From: Martyn White
Sent: 22 February 2019 10:37
To: Planning.Responses
Cc: Zac Denton
Subject: EP/6/19/PL

EP/6/19/PL

I note that the application relates to alterations to, and change of use from, an existing dwelling to a garden room. The change of use is considered to be acceptable, as are the internal alterations.

DETAIL: GARDEN HOUSE
PROPOSED ROOF PLAN

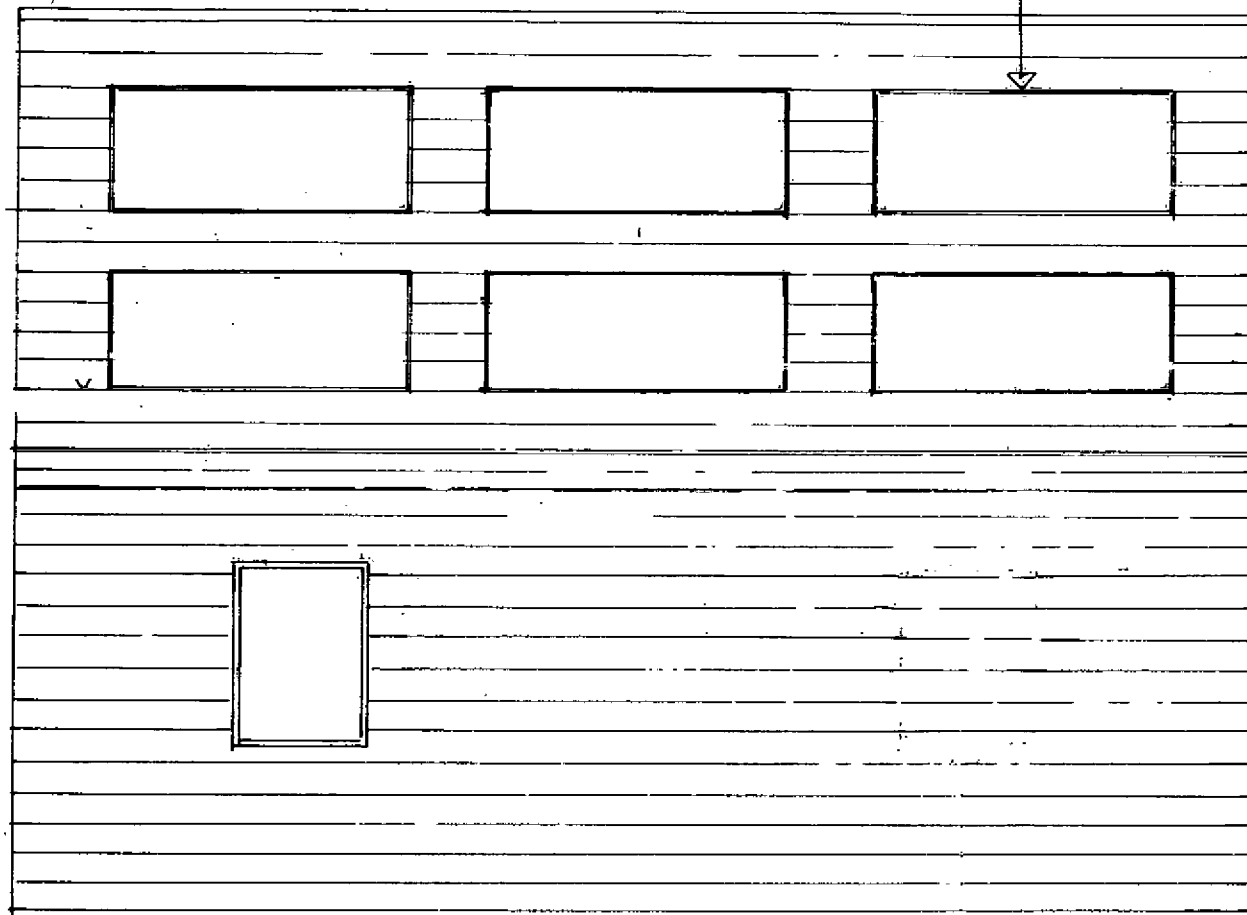
The use of the cladding is considered to be acceptable in principal. However, it is not clear how it will be treated. Please can this be confirmed? Further, I also note that the intention is to use solar panels on one of the roof slopes. Such a proposal will affect how the building is viewed from the surrounding areas, and could be considered unfortunate. However, if designed sensitively along with the proposed roofing material, the impact could be minimised to a point of being acceptable.

MCA INTERIORS
30 Ennismore Avenue London, W4 1SF.
Tel: 07768 743629 Email: mcainteriors@hotmail.com
PROJECT: GARDEN HOUSE SEA RD EAST PRESTON SUSSEX BN16 13P
DETAIL: PROPOSED FLOOR PLAN & ELEVATIONS GARDEN HOUSE
SCALE: 1:50
DRWG. NO: 253/01 (15/10/2018)
AMMDS: REV. A: (30/11/2018)

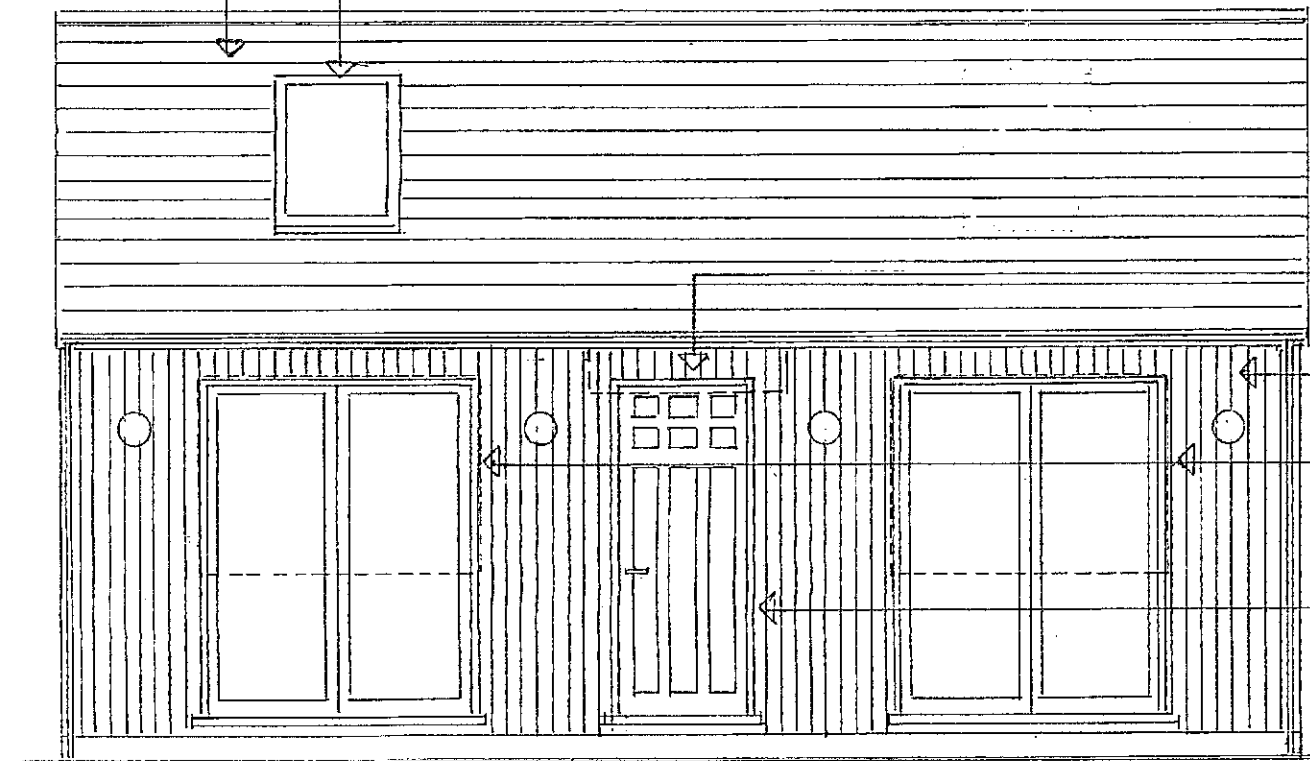
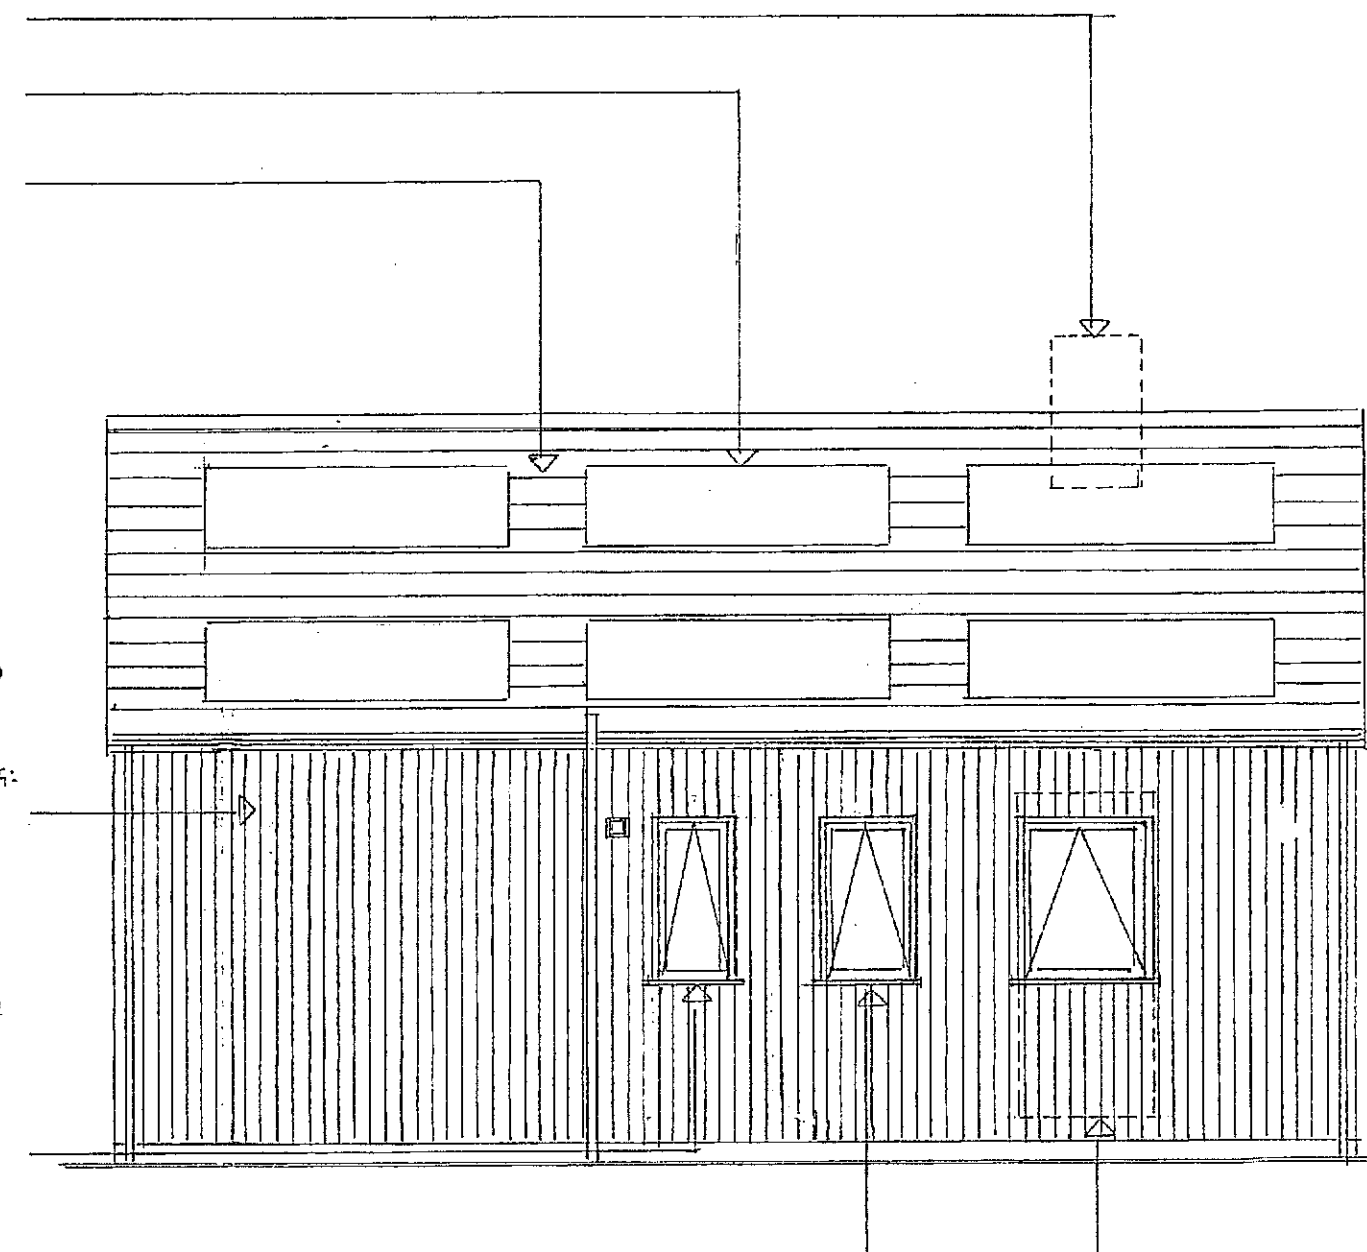
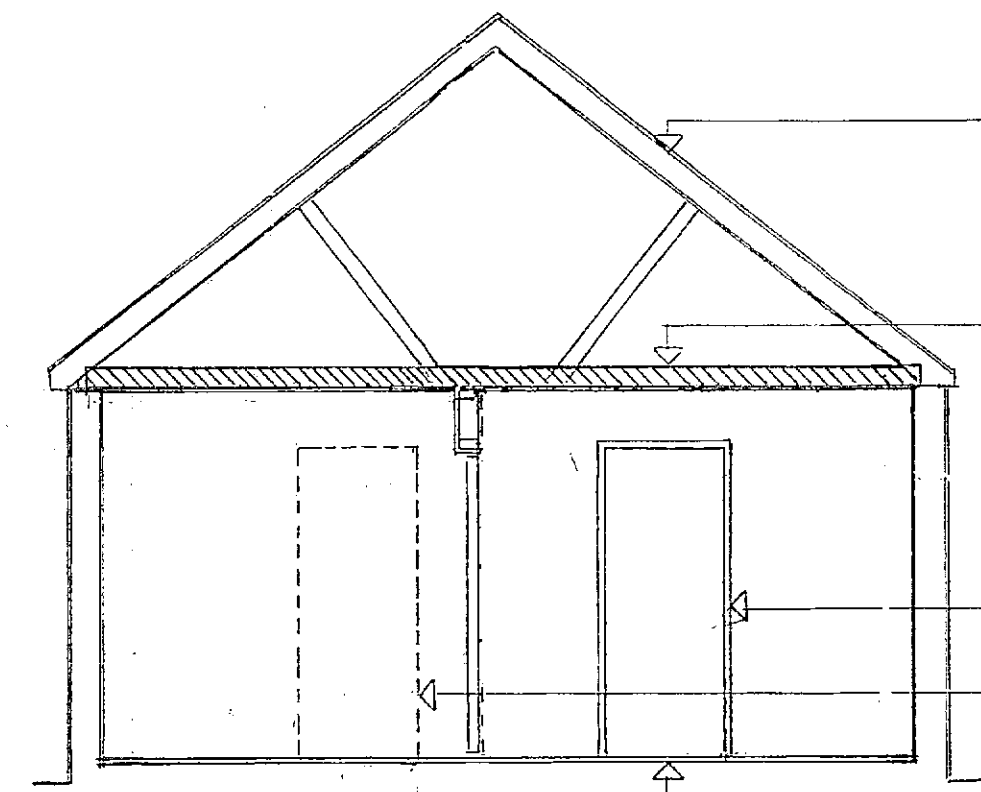
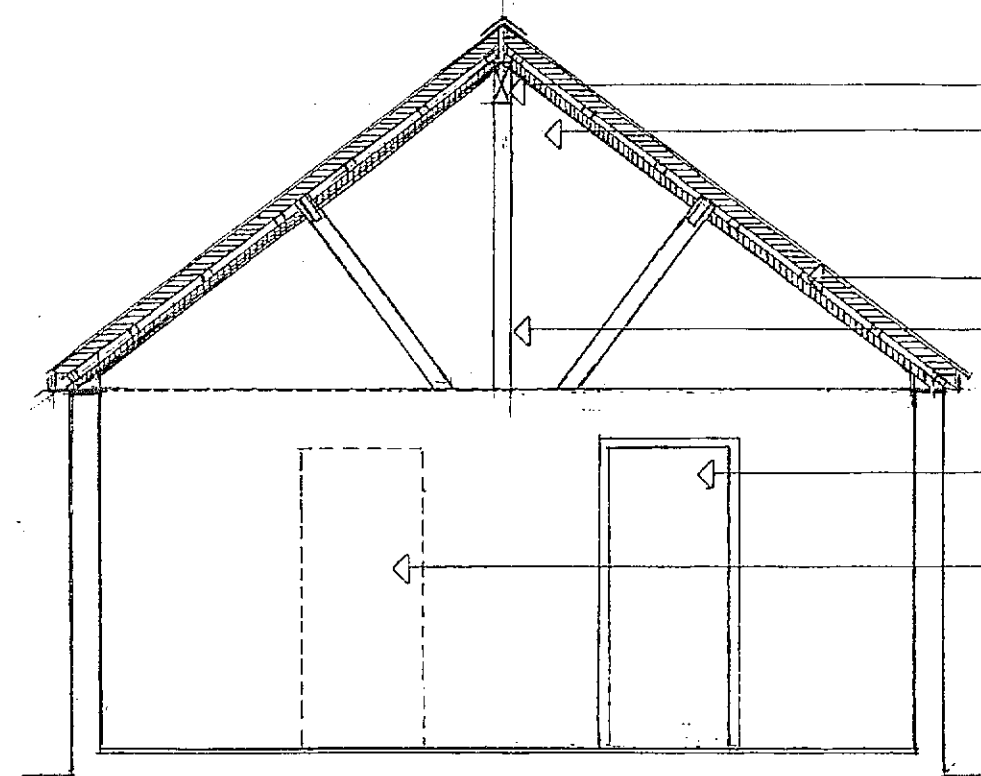
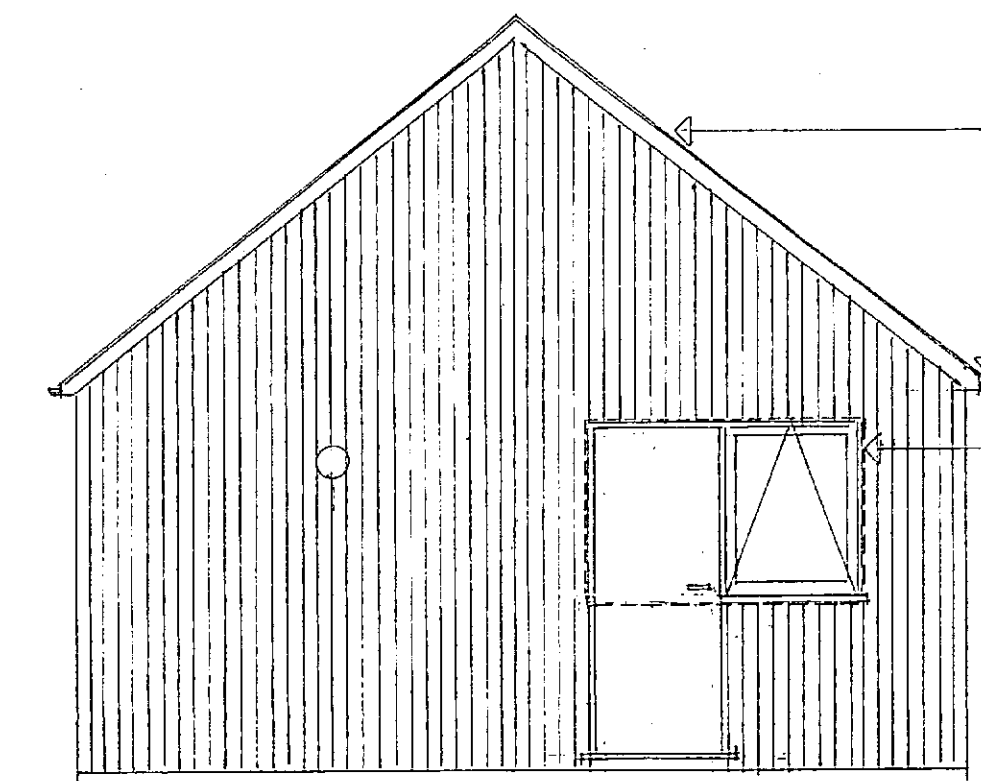
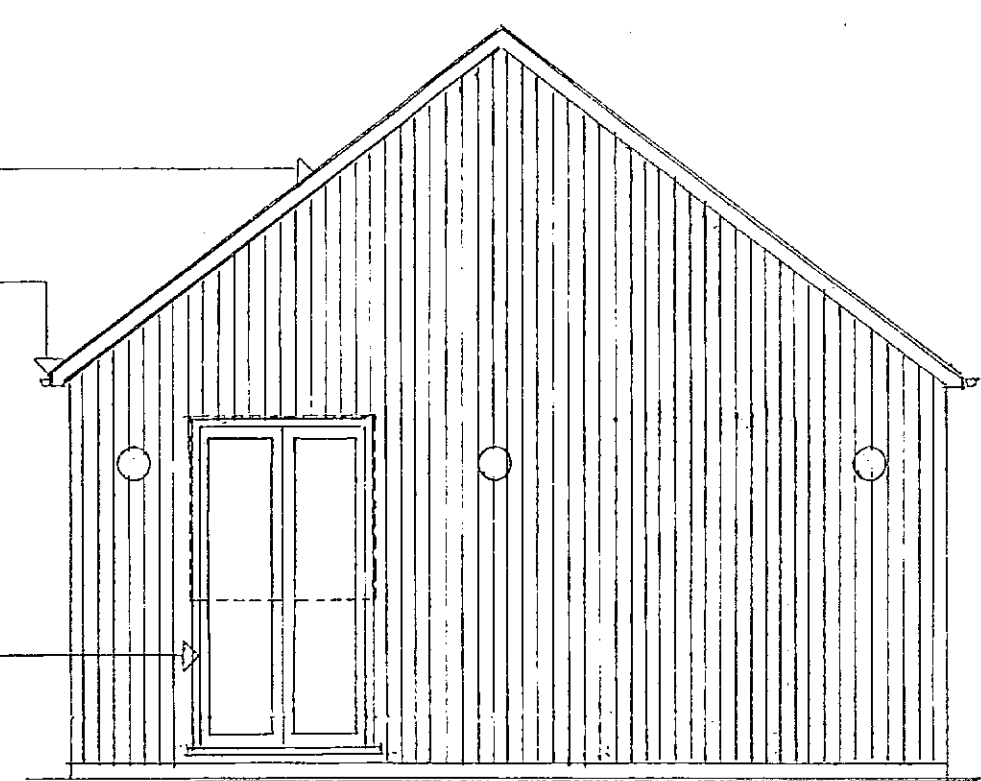
Reference is made to a proposed window/door specification on the plans, but I cannot see this within the application (when viewed digitally). Is this missing? Otherwise you may wish to request that details are provided to the council in order to ensure that they are acceptable?
